**DEVELOPMENT REVIEW BOARD
ACTION SHEET**

May 30, 2007

Project # 1005239

DATE: May 22, 2007
TO: Sheran Matson, DRB Chair
FROM: Catalina Lehner, Senior Planner *cll*
RE: Project #1005239, Tract K-1 of the Gateway Industrial Park

PRELIMINARY LANDSCAPE PLAN

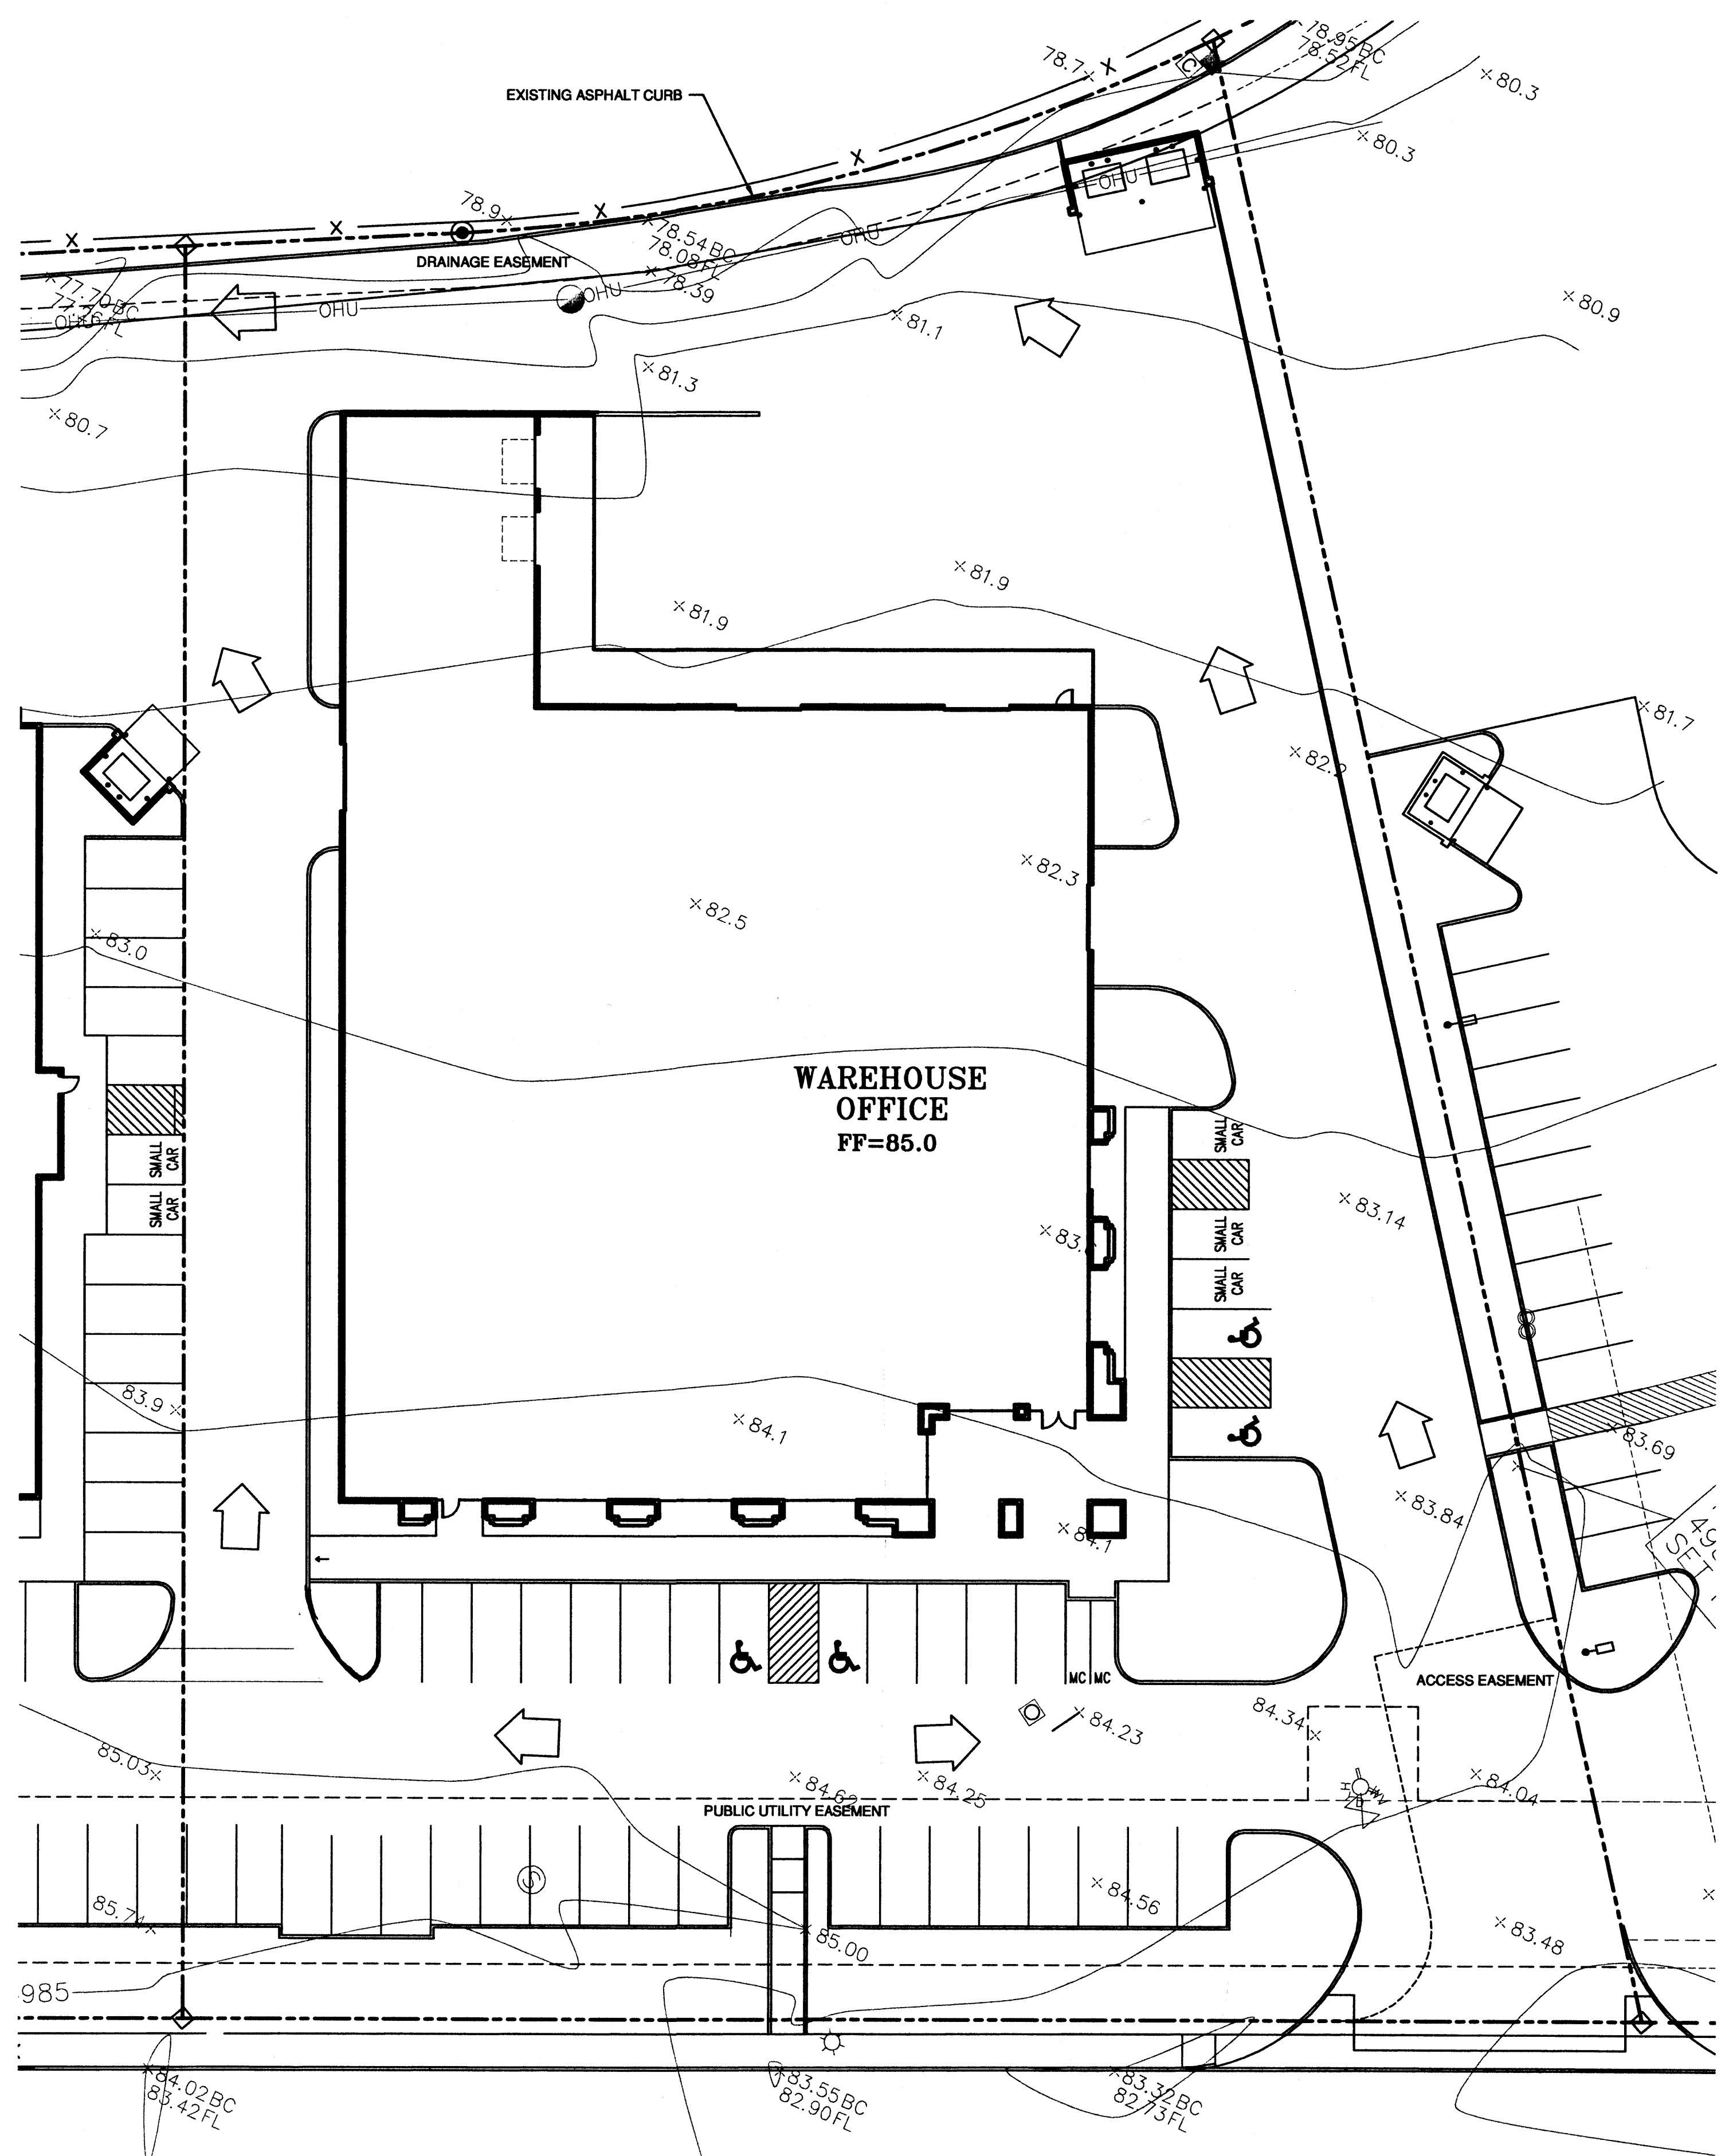
Condition #7C: This condition has not been met. It appears to me that the landscaping does not meet the requirement for 75% coverage with living vegetative materials. Tree canopies don't count. Coverage appears sparse on the middle island on the northern side, on the southeastern "bump out" area, and along the eastern landscape buffer in certain places.

Condition #7G: This "planting area" is now shown as landscaped to match the rest of the site, which Staff finds acceptable since it provides more than what the original condition required.

PRELIMINARY SITE PLAN FOR BUILDING PERMIT

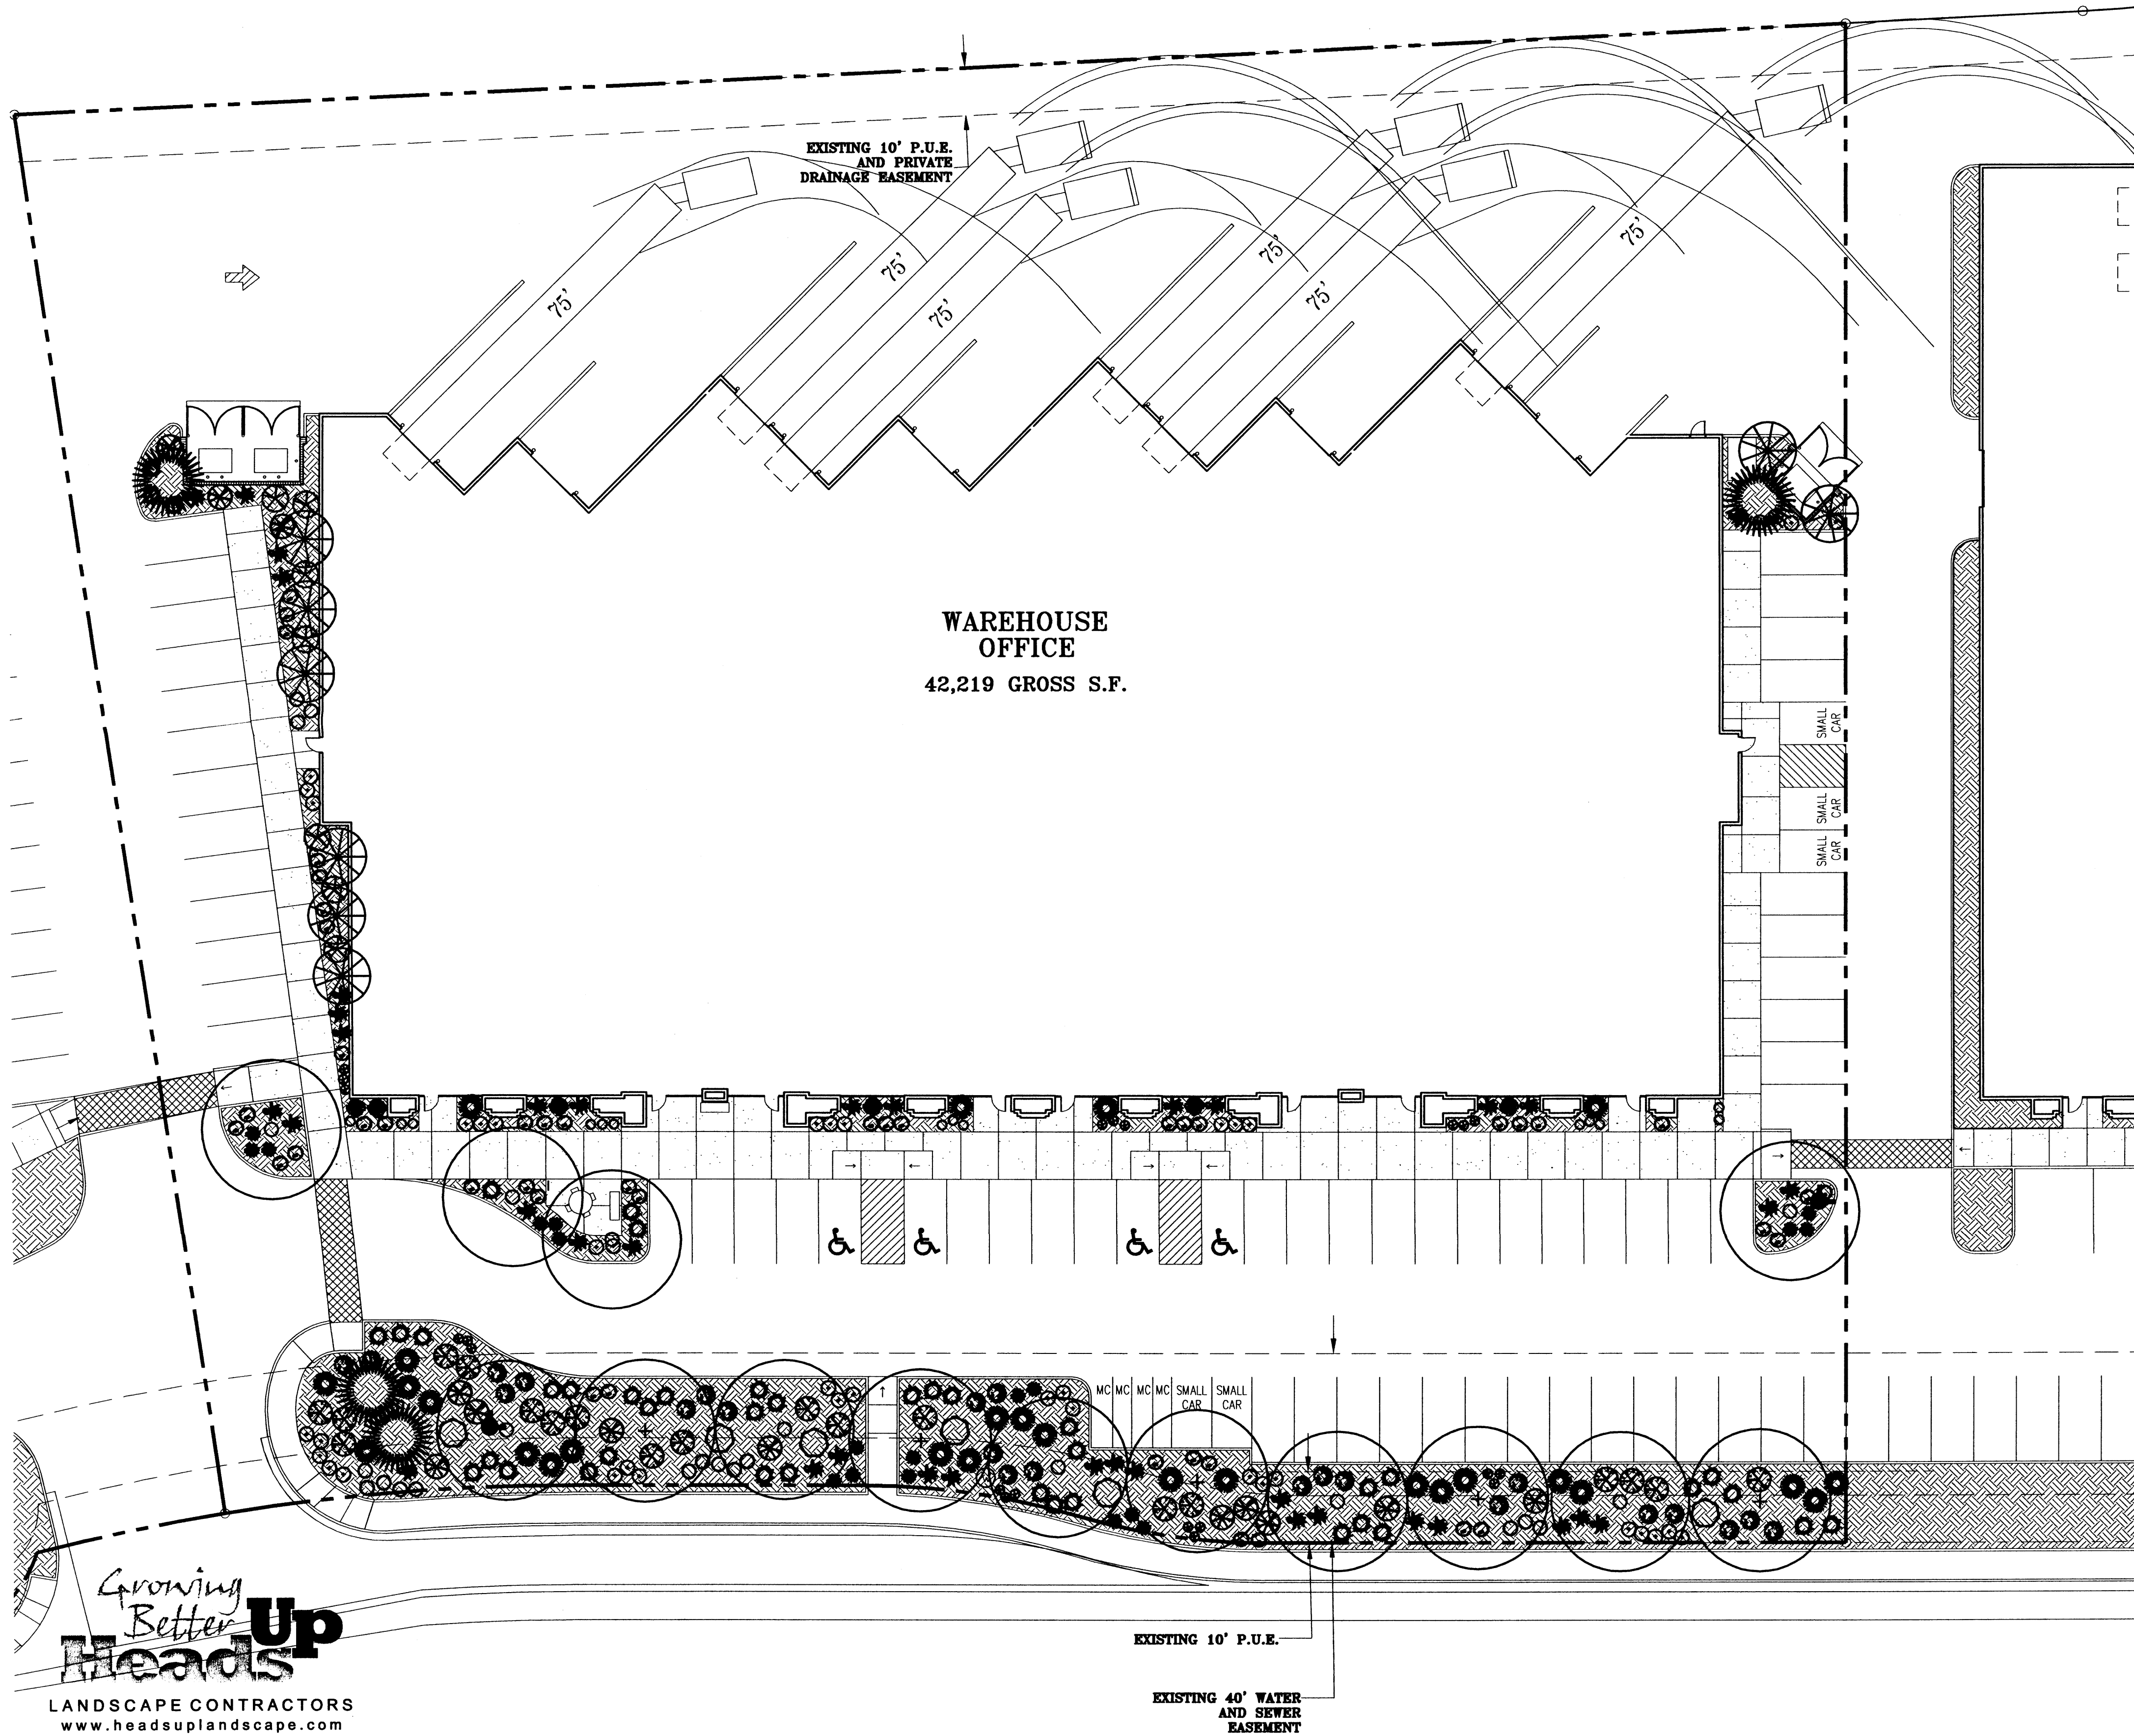
Condition #3A: A sign has been added to minimize the possibility of vehicle/truck conflict. The applicant was going to "call it out" using a sharpie, but apparently forgot to do so. A label needs to be added to identify the sign.
